Phone: 0300 123 6780
Email: SUDS@lancashire.gov.uk
Date: 24 August 2020

APPLICATION CONSULTATION RESPONSE

| Application: | 3/2020/0325 |
| Location: | Land north of Chatburn Road Clitheroe BB7 2EQ |

DRAINAGE LONG SECTION

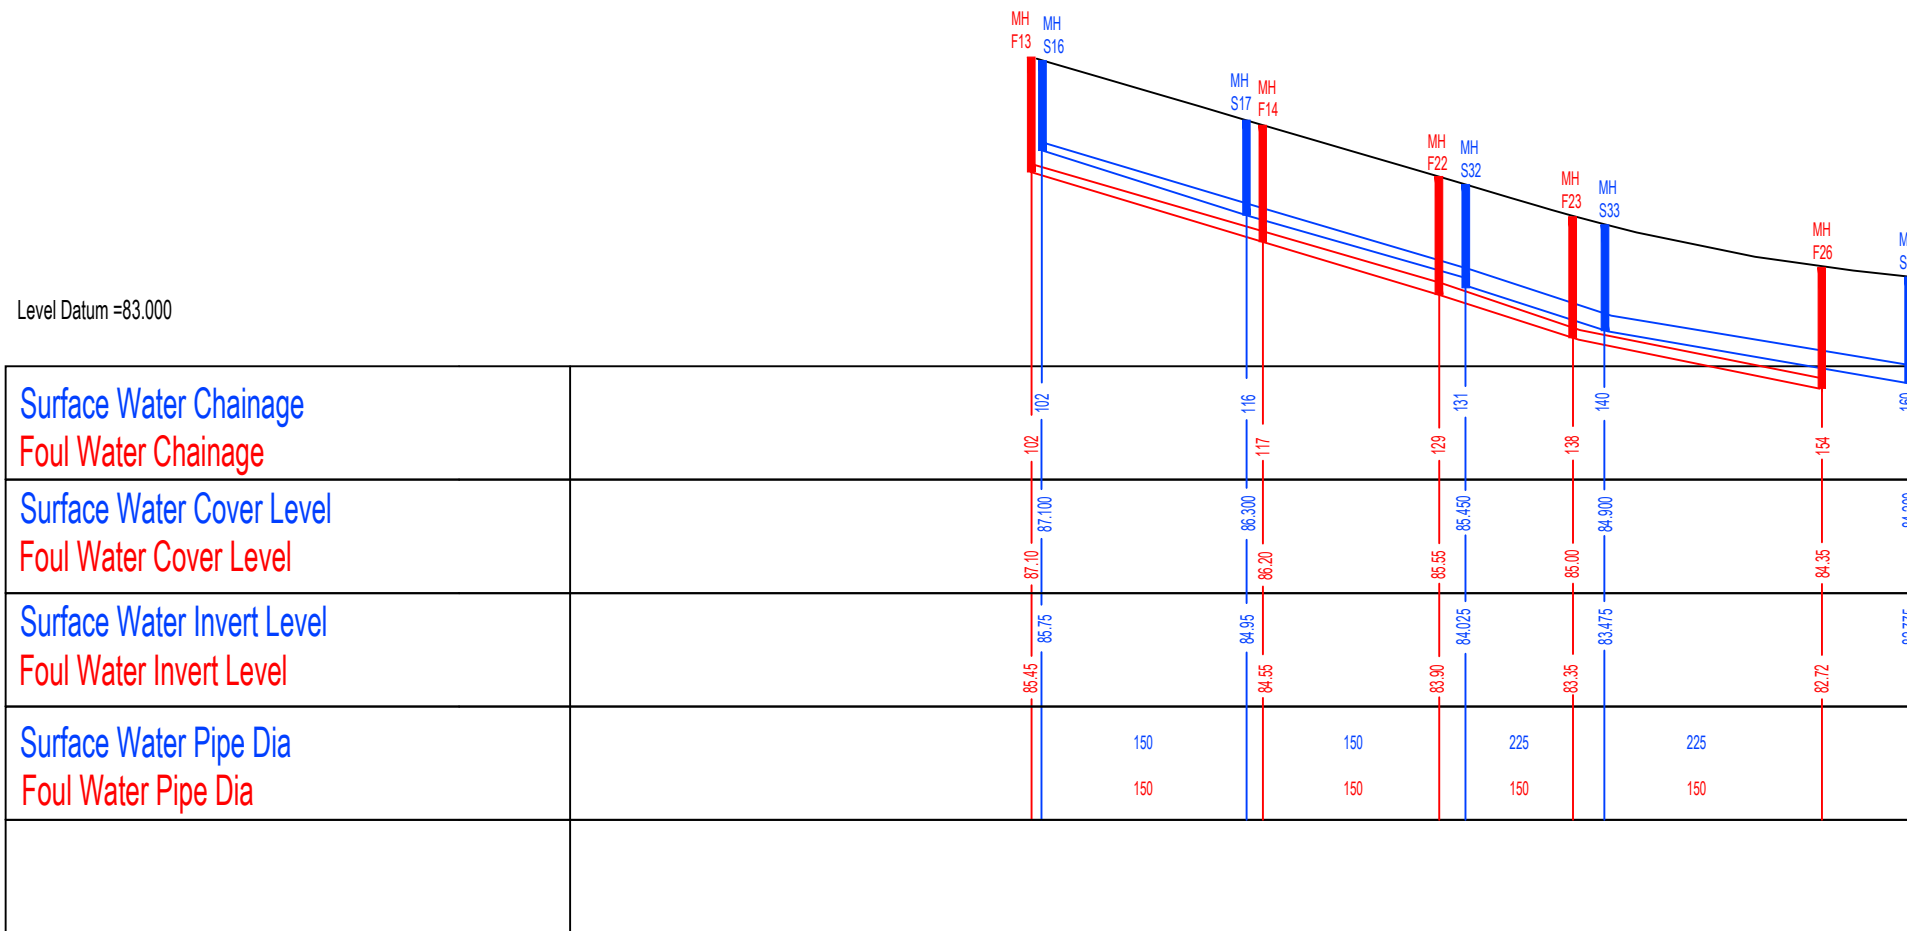
| Outstanding information: | |
|--------------------------|--|
| a) | An assessment of the existing and proposed surface water runoff volumes. This is to demonstrate the requirements of standard S4 of the non-statutory technical standards for sustainable drainage systems can be complied with; at least in principle. |
| b) | Updated surface water flow calculations that include an additional 40% allowance for climate change, rather than the additional 30% allowance that has currently been provided. This is in line with Environment Agency guidance on climate change allowances - https://www.gov.uk/guidance/flood-risk-assessments-climate-change-allowances (see table 2). |
| c) | An updated surface water drainage layout plan to include all pipe numbers and references (i.e. PN1.000, PN1.001 etc). This is to allow the drainage layout plan to be cross referenced with the supporting flow calculations. |

| c) | Confirmation of whether the proposed surface water drainage strategy has been submitted for approval, or whether it is still subject to change following further detailed design and investigation. |
